P/25/17/OUT: Outline application for access only - Erection of up to 89No. dwellings, access roads, landscaping, open space & associated works. This application is a Departure from the Development Plan. Land at Church Barton House, Pagham

P/140/16/OUT: Outline application for access only - mixed use development comprising of up to 400 dwellings, a care home with up to 70 beds, a Local Centre comprising up to 2000sqm of A1/A2/A3/D1/sui generis floorspace, provision of land for a 1FE primary school (with sufficient space to ensure that it is expandable to 2FE), provision of land for a scout hut, safeguarding of land to help link the site to the Pagham Harbour Cycle Route & other community uses including public open space & allotments with some matters reserved. This application is a Departure from the Development Plan. West of Pagham Road, Pagham

P/6/17/OUT: Outline application with some matters reserved for construction of up to 300No. new homes, Care home of up to 80No. beds, D1uses of up to 4000sqm including a 2 form entry Primary School, formation of new means of access onto Hook Lane & Pagham Road, new pedestrian & cycle links, the laying out of open space, new strategic lands

Figure 13.2 - A27 Whyke Hill junction mitigation scheme

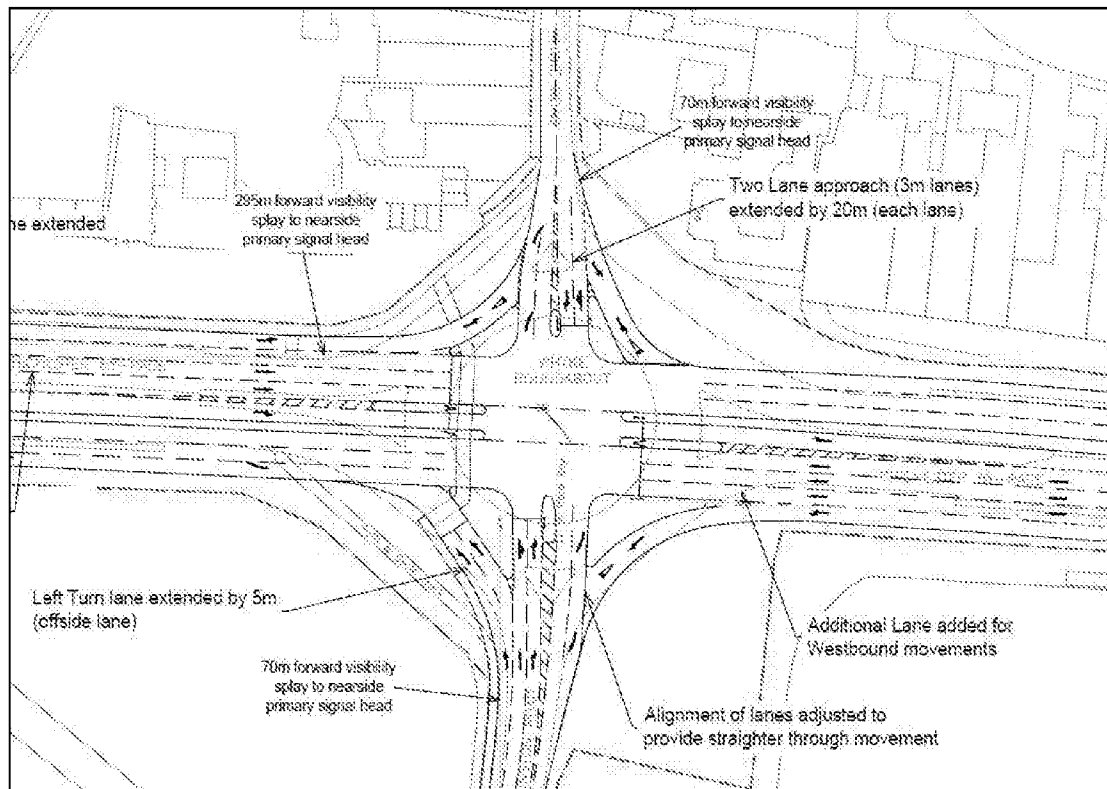
The traffic generated by the developments proposed above would, without effective mitigation, result in a severe impact on the roads and junctions within Chichester District, particularly the A27/B2145 junction (Whyke Roundabout) and the A27/A259 junction (Bognor Road Roundabout) on the trunk road network, and the Runcton and North Mundham/Hunston roundabouts on the WSCC road network (NPPF paragraph 32 applies). These junctions already generate significant delays at peak times from existing developments within Chichester District and the high volume of through traffic. All development within the Chichester Local Plan has been assessed for its impact on the A27 and related junctions, with mitigation secured through the Local Plan for allocated sites, or on a bespoke basis for additional development. CDC would expect ADC to adopt the same approach in partnership with West Sussex County Council and Highways England.

CDC encourages ADC, WSCC and HE to review these proposals carefully to ensure that they are satisfied that the data presented is accurate and the works proposed will be effective. Until such time that HE and WSCC confirm their satisfaction with all aspects of the mitigation, including physical works, costing and timetables, CDC wishes to express strong concerns about the highways and transport impacts of the proposed developments.
